ENG-CS23003-R1-TIS.pdf Markup Summary

El Paso County, Colorado
February 16, 2023

Traffic Impact Study
Mayberry Communities
Filing 4 Traffic Impact Study

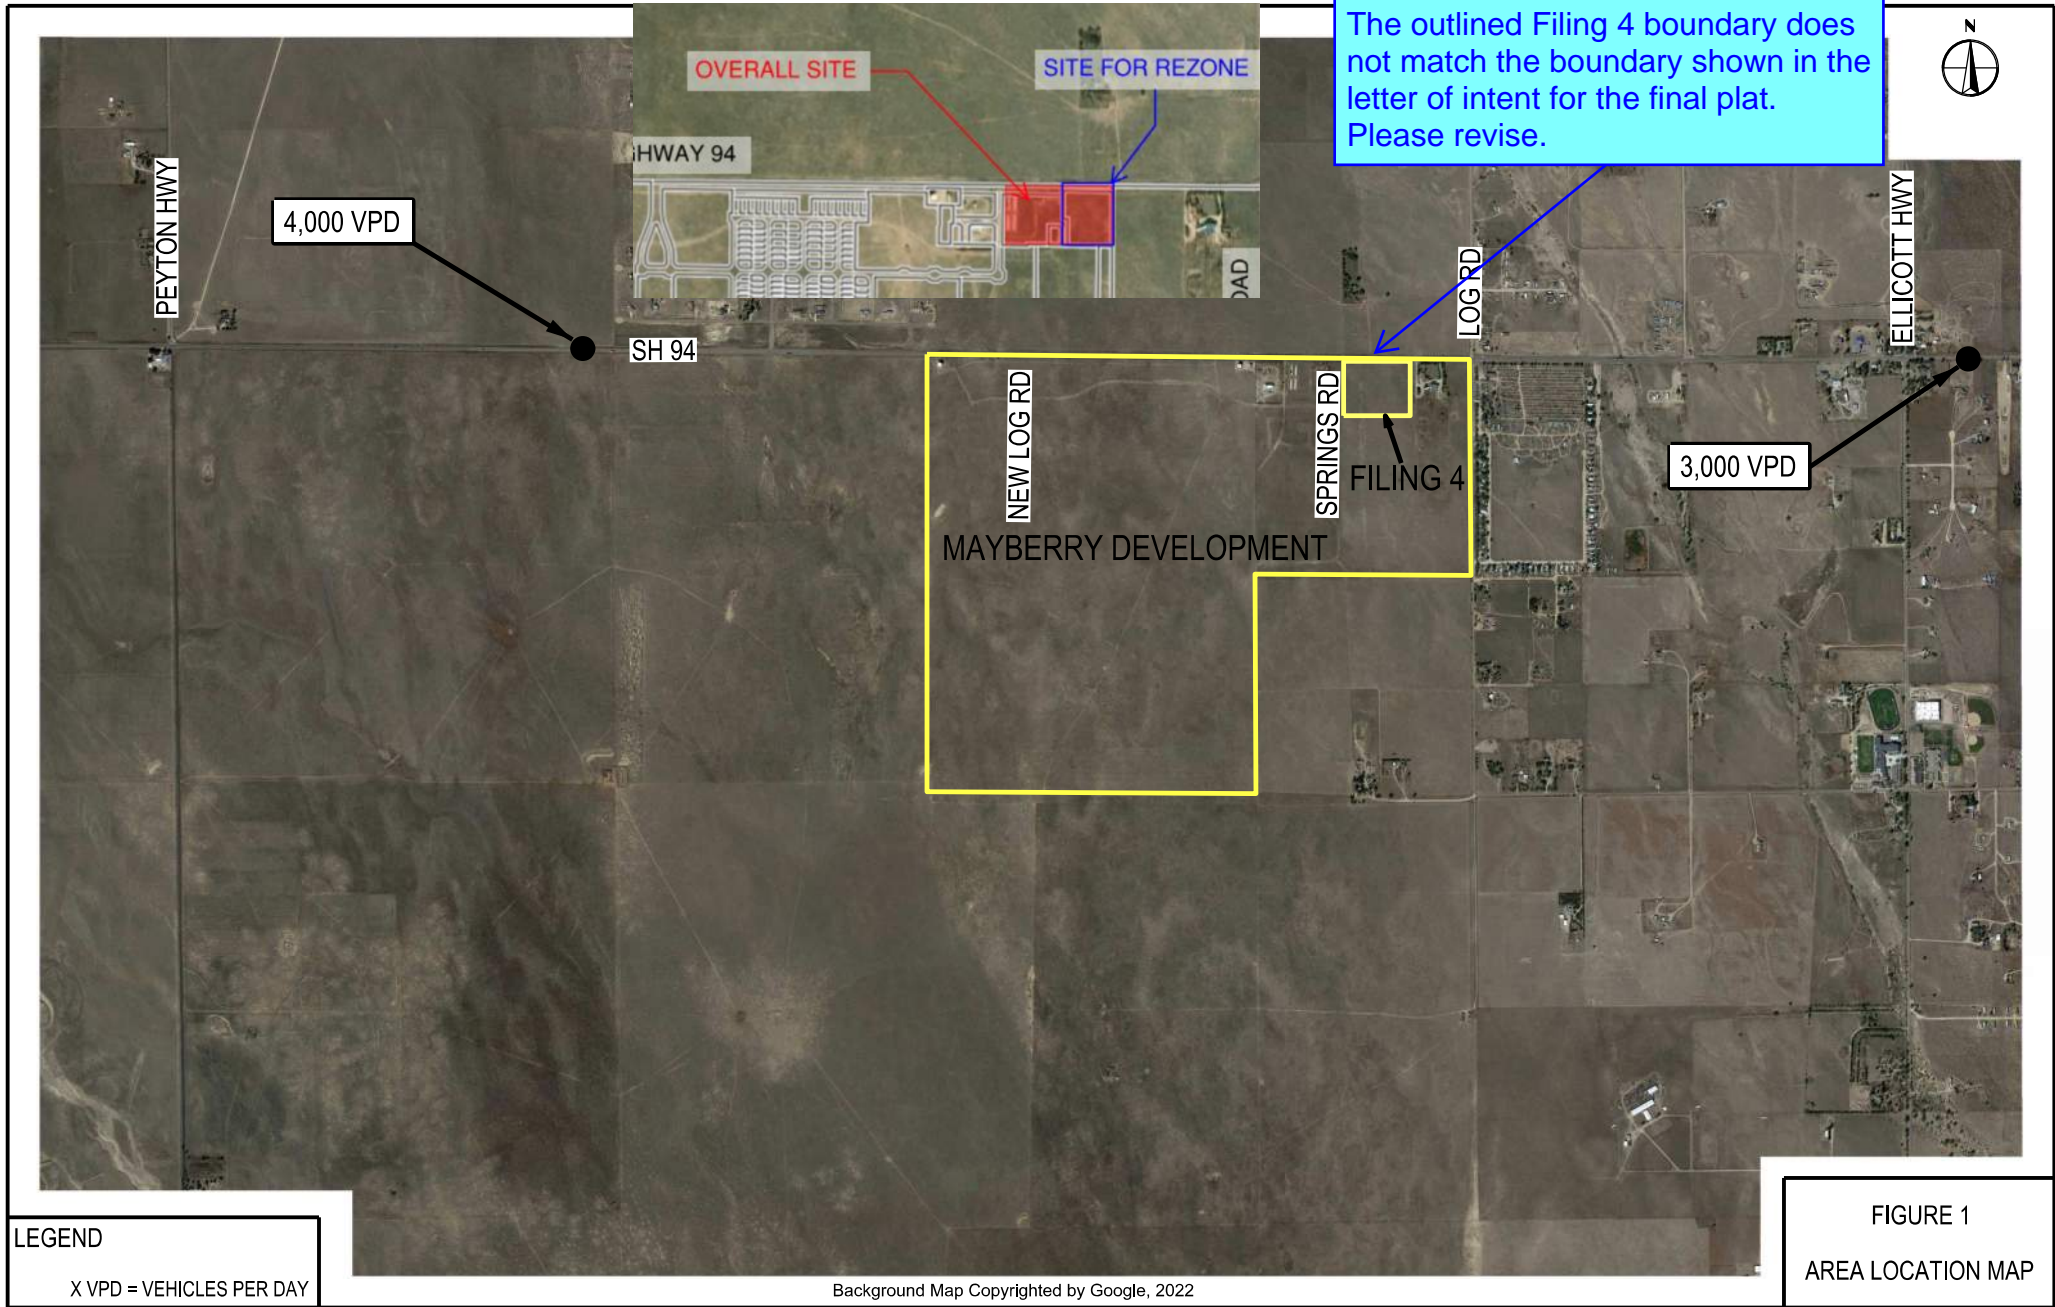
The outlined Filing 4 boundary does not match the boundary shown in the letter of intent for the final plat. Please revise.

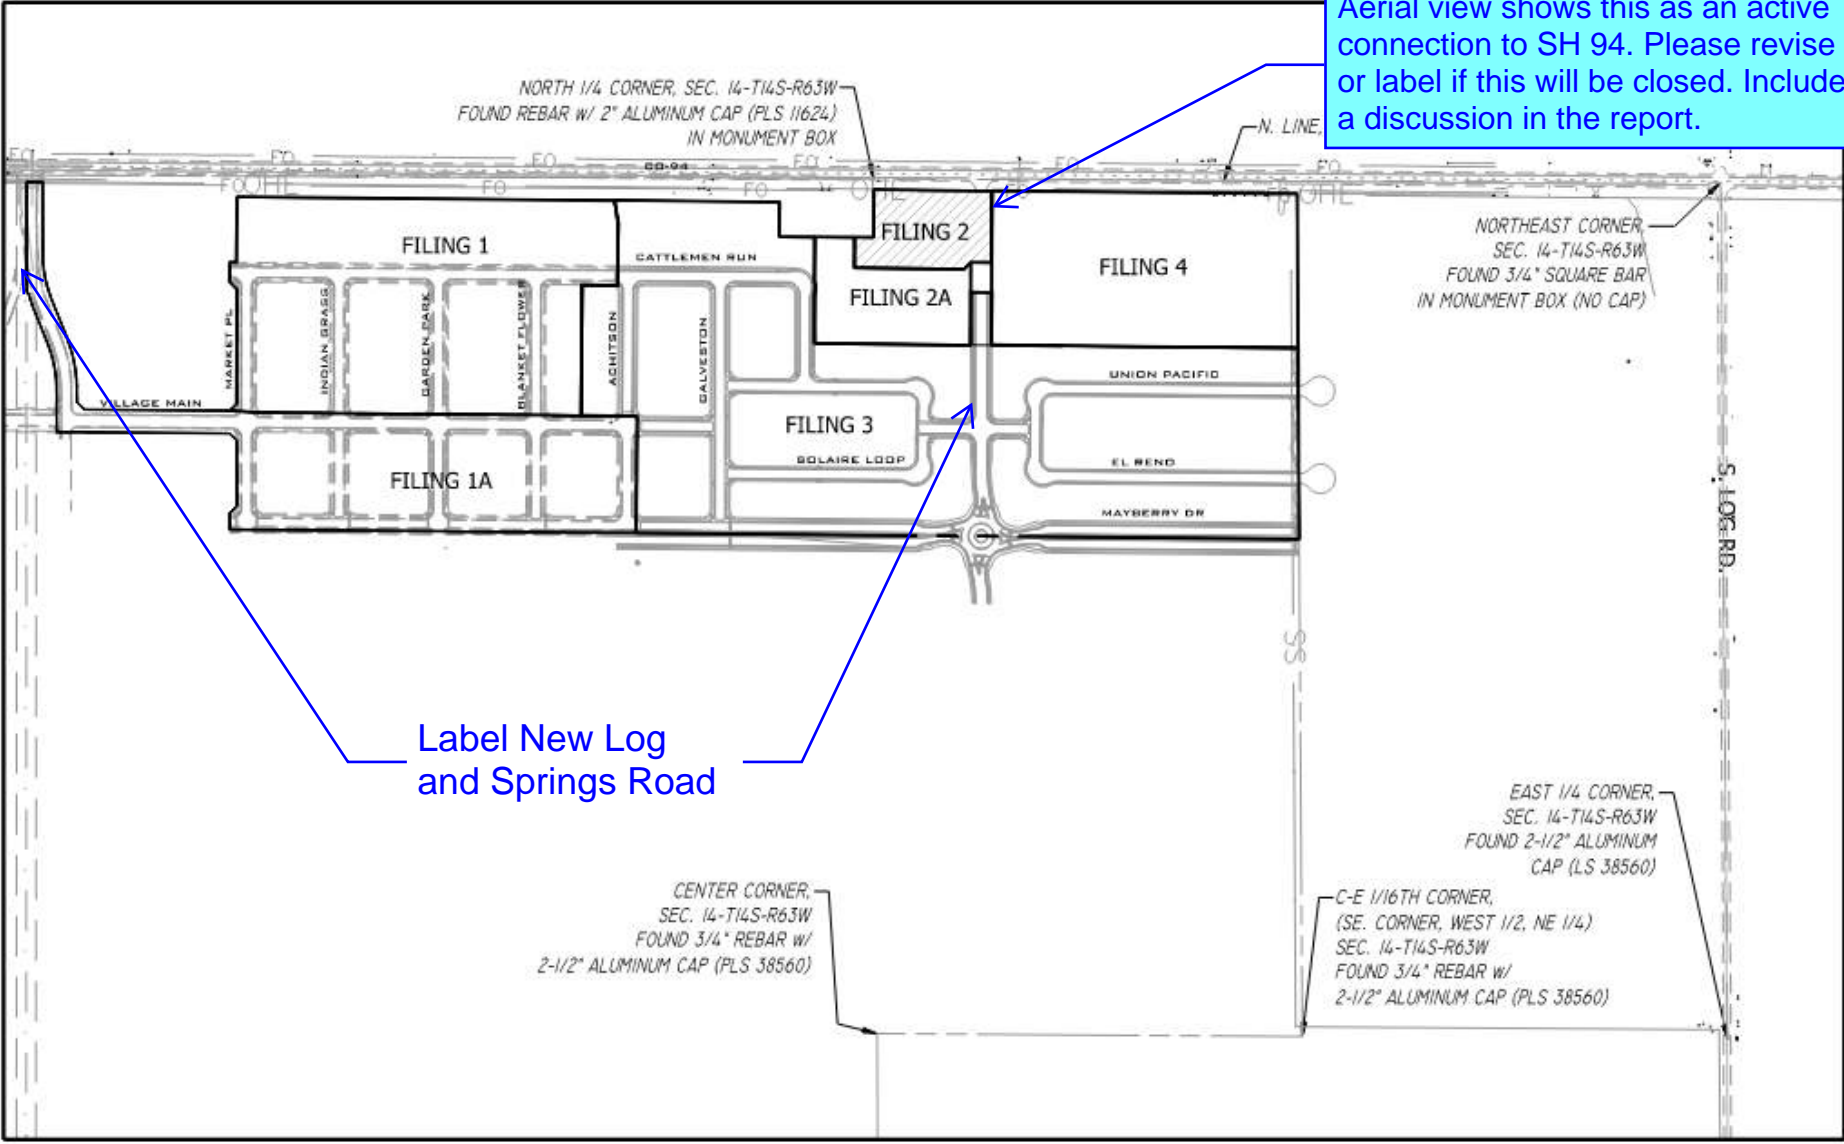
Label New Log and Springs Road

Aerial view shows this as an active connection to SH 94. Please revise or label if this will be closed. Include a discussion in the report.
